**Planning Department  
Transportation Development Services**

November 14, 2014

**Re: Applebee's- Montañó Plaza, 6200 Coors Blvd.  
Submittal for Certificate of Occupancy – Transportation Development**  
Engineer's Stamp dated 05-19-14 (E12-D003A)  
Certification dated 11-03-14

cp-102

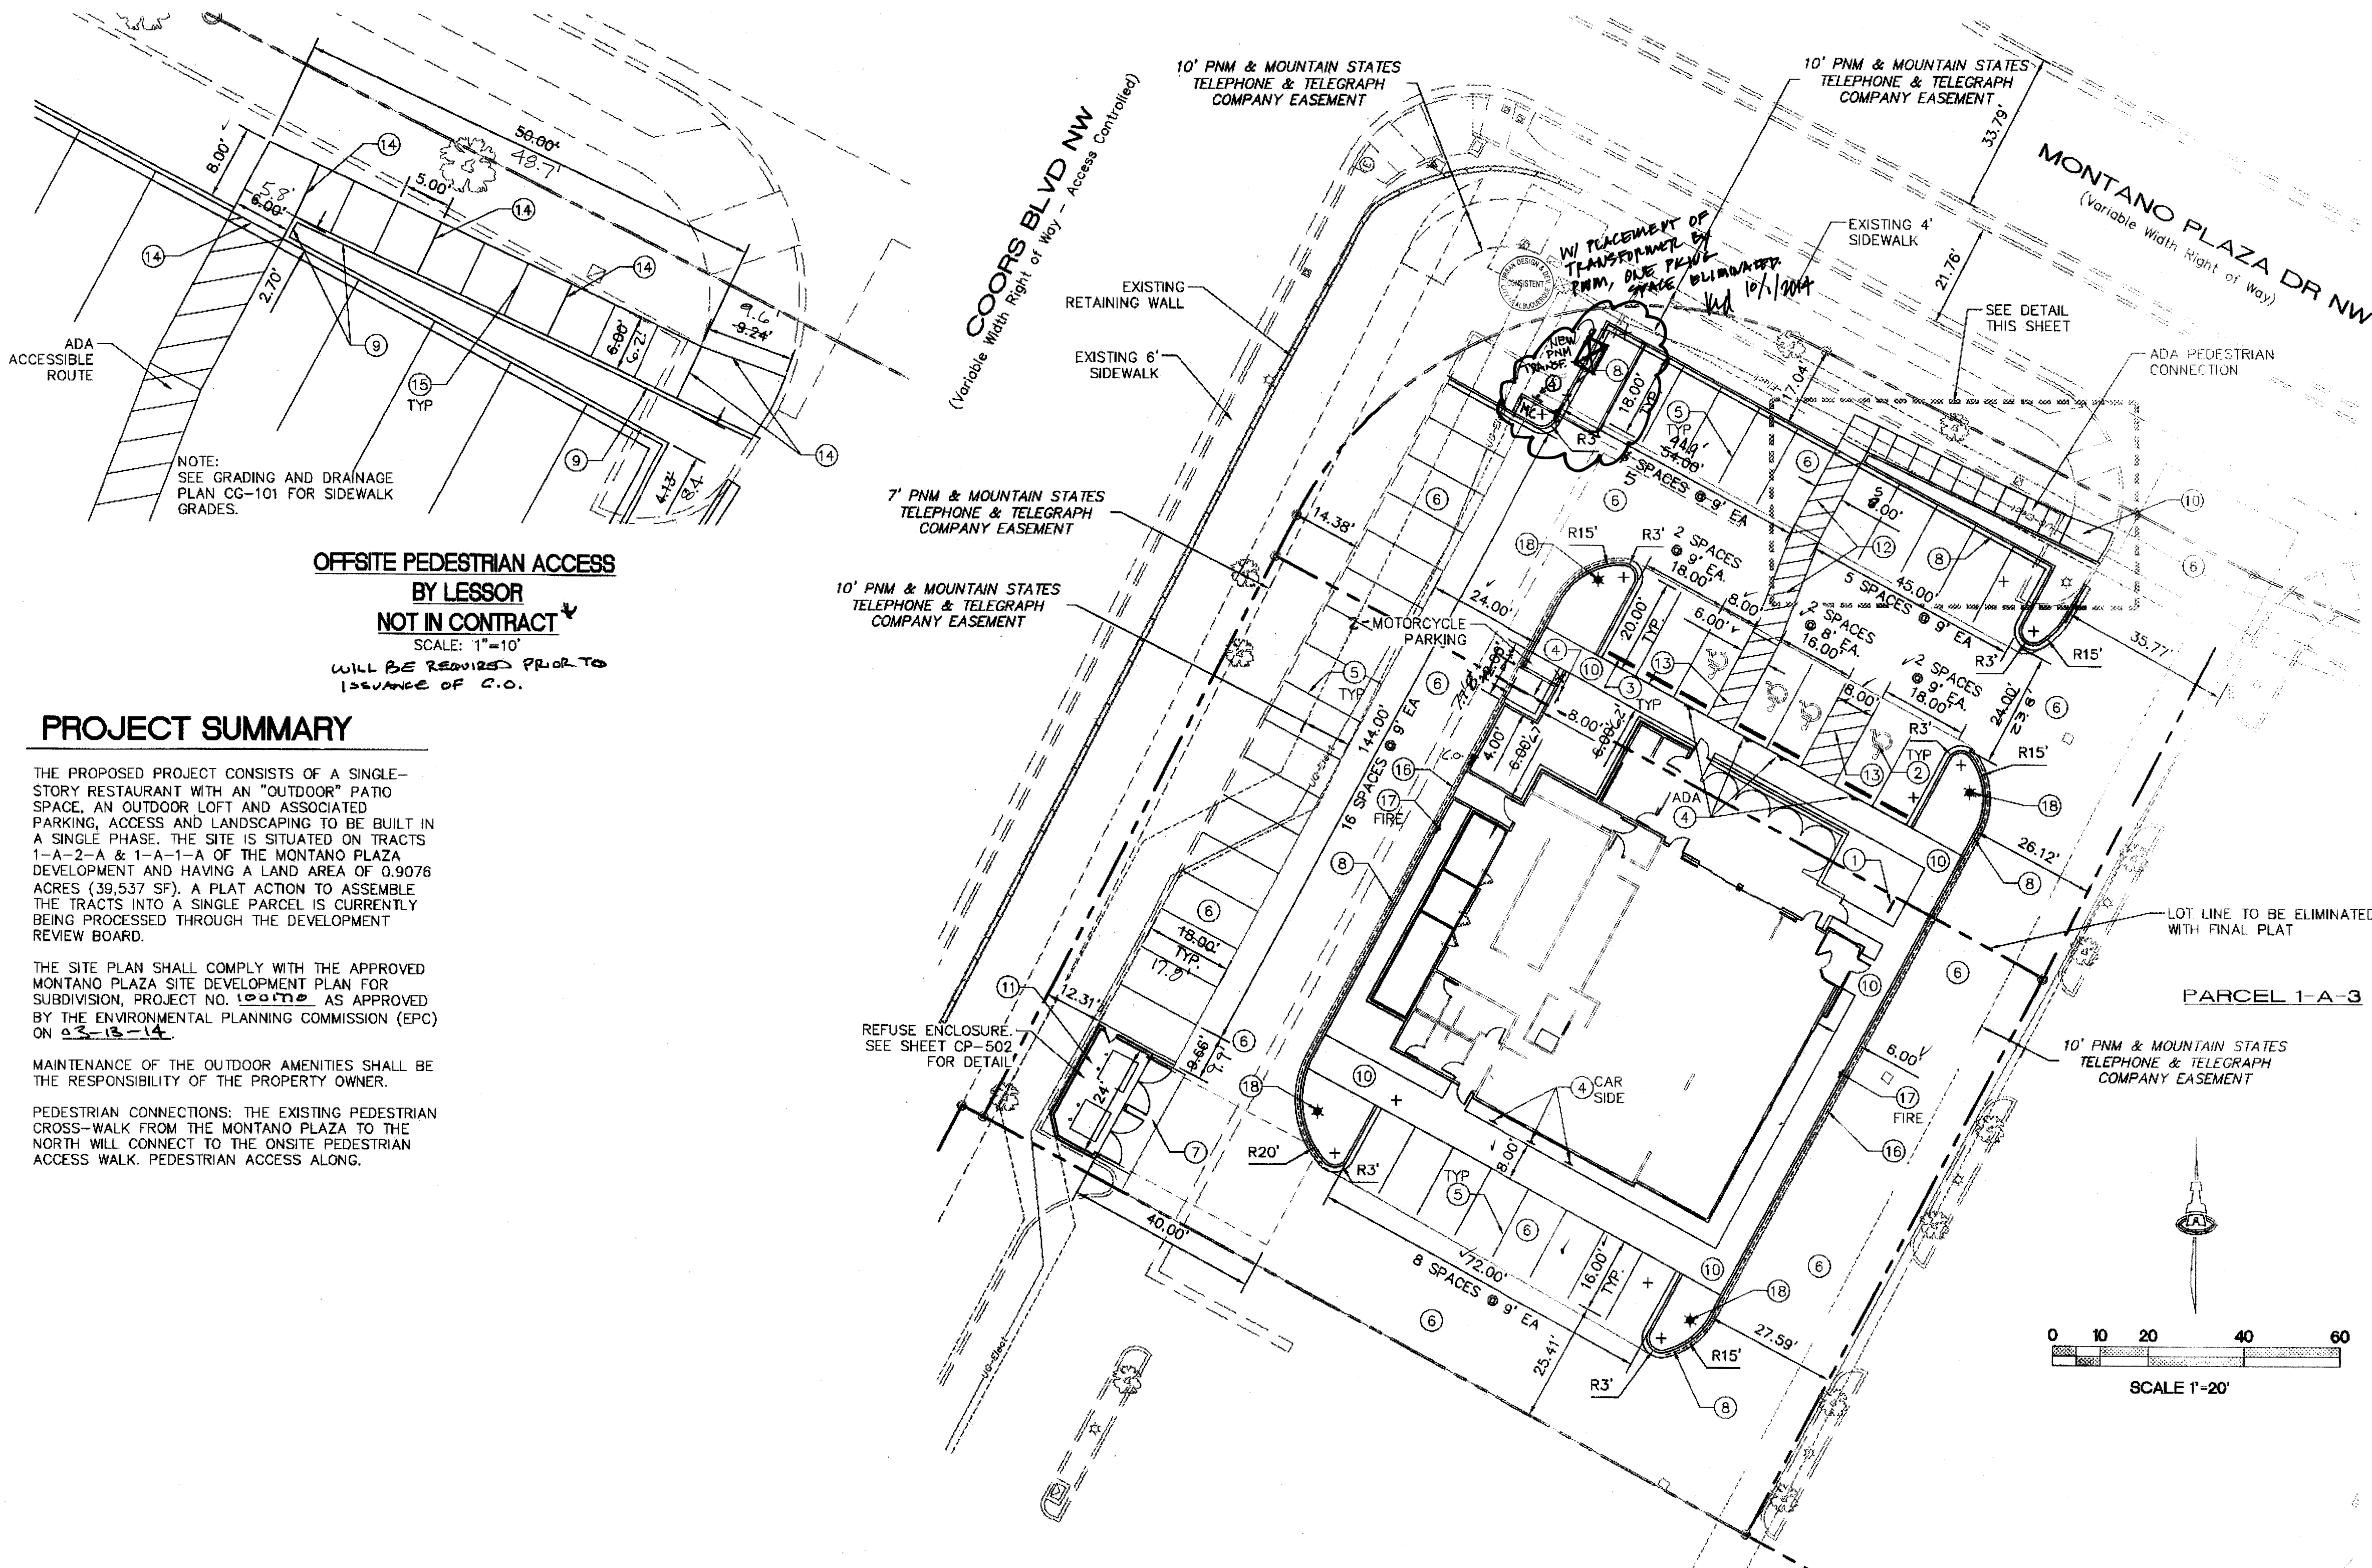
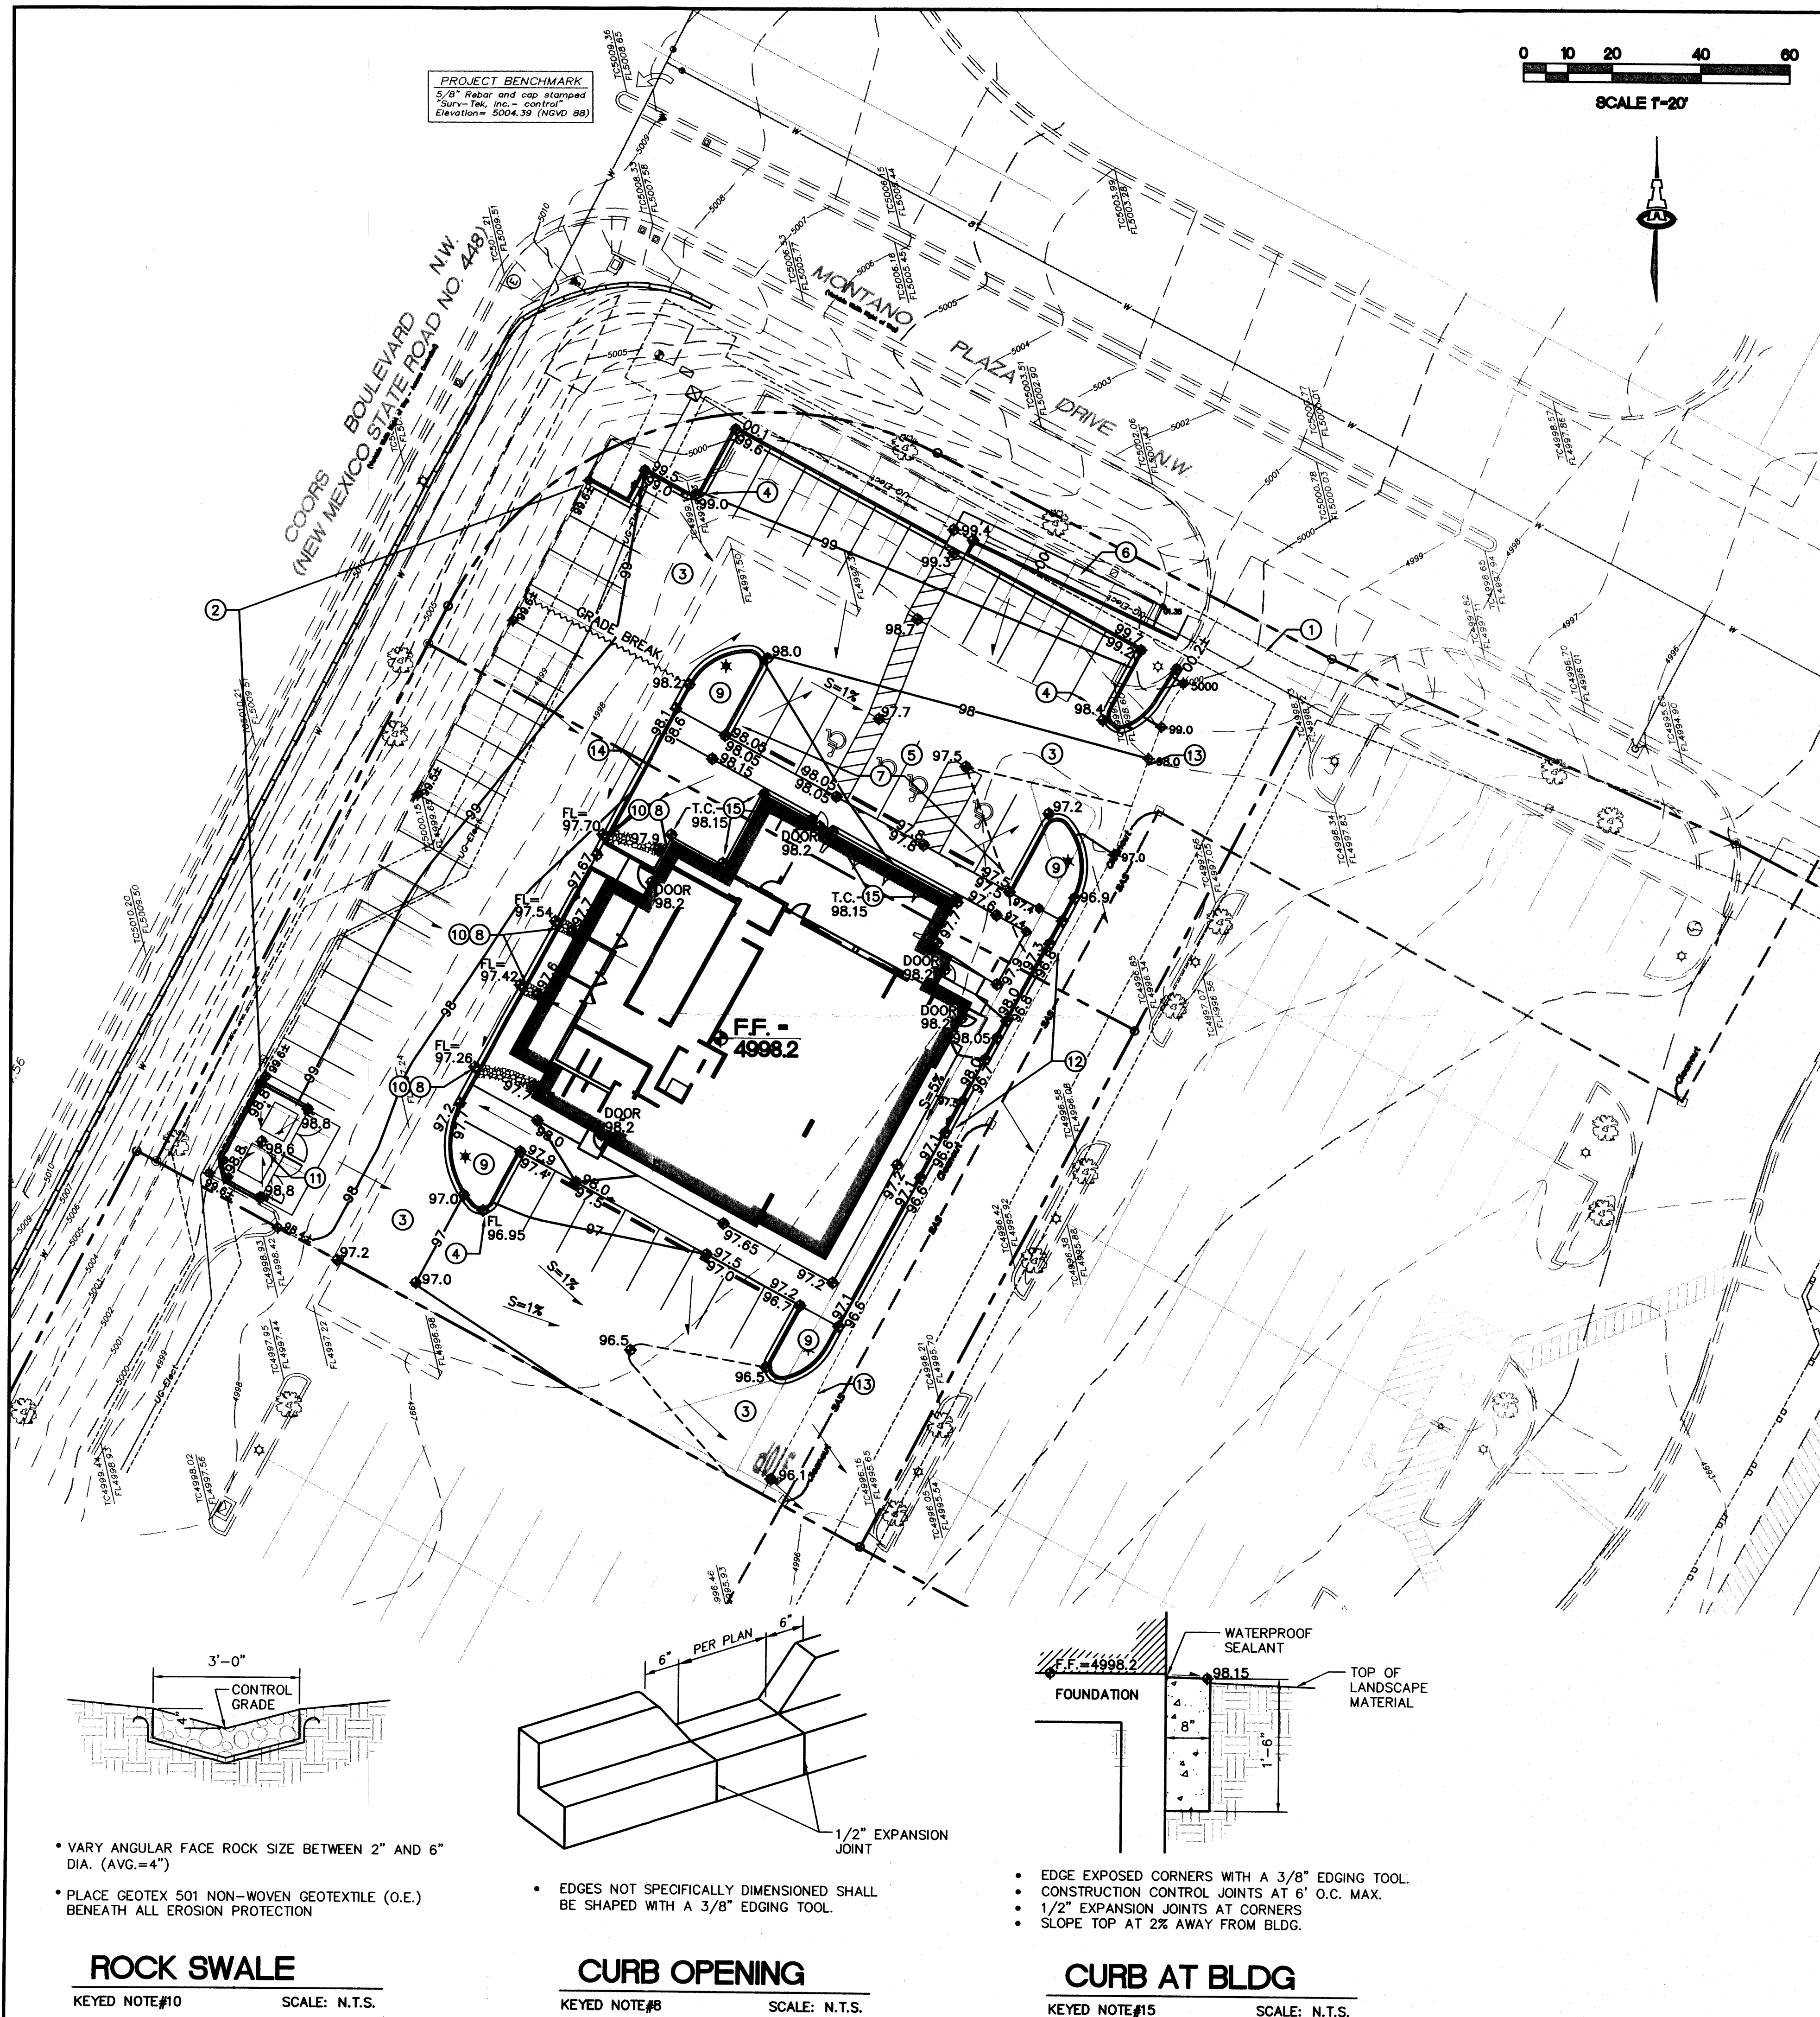
- The DRB Site Plan (or most recent AA) submitted for Final C.O. needs to be the latest edition, which may have redlined comments, initialed and dated by the designer-of-record.
- Engineer's Certification language needs to certify the transportation improvements rather than the hydrology improvements.
- The site needs to be cleared of construction materials and equipment.
